Date: 29-May-2024
Our Ref: 2024/91103

**Application for a non-material amendment following a grant of planning permission,
Town and Country Planning Act 1990**

**Non material amendment to previous permission 2022/91589 for erection of first
floor side extension, front porch and extensions and alterations to detached garage
62, Park Lea, Bradley, Huddersfield, HD2 1QP
Application Number: 2024/91103**

1 Ground Floor Plan  
1 : 100

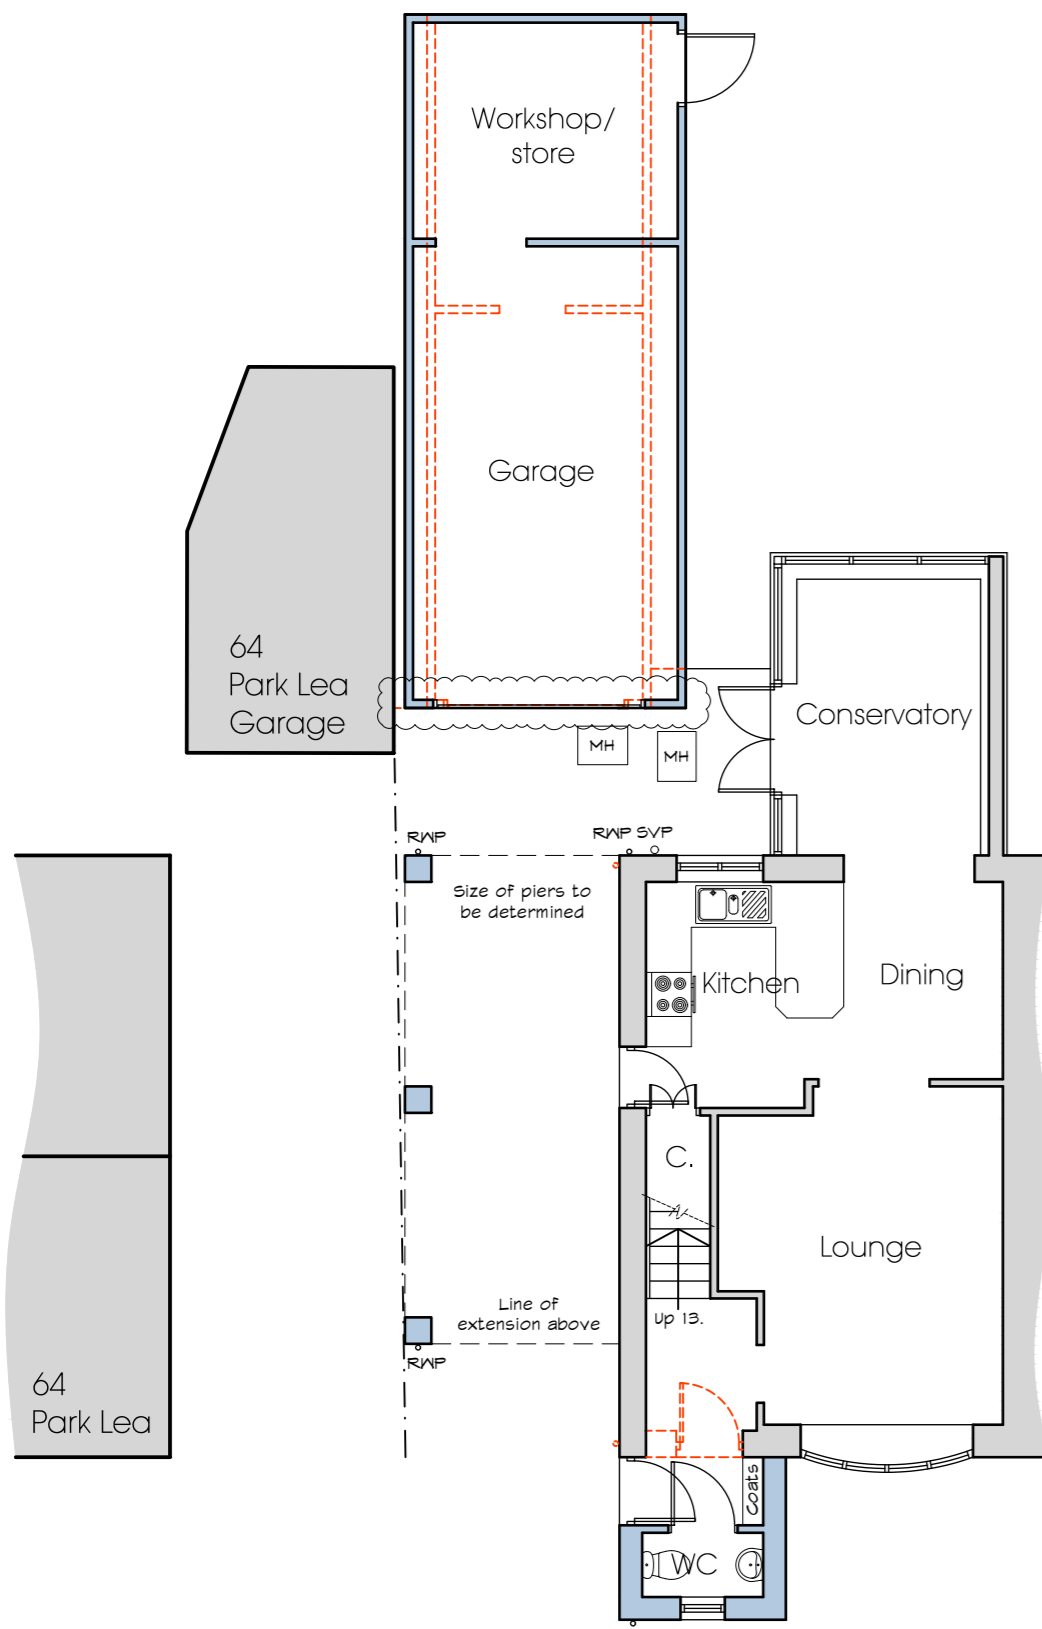
Thank you for your application dated 18-Apr-2024 for a non-material amendment to the above scheme. The amendment sought is to add a solid timber dark grey door (no glazing) to the northwest elevation of the proposed single-storey detached garage as located on the proposed floor plan within drawing number 0701, revision P06 - Plans and Elevations as Proposed.

I confirm that the alterations are acceptable and may be considered as a non-material amendment to the approved drawings. It should be noted that this letter relates only to the non-material amendment sought and it is not a re-issue of the original planning permission. The two documents should be read together and as such, all conditions imposed on the original granting of planning permission apply to the proposal as now amended. A copy of this letter and the amended plans will be retained on the public record of approved documents.
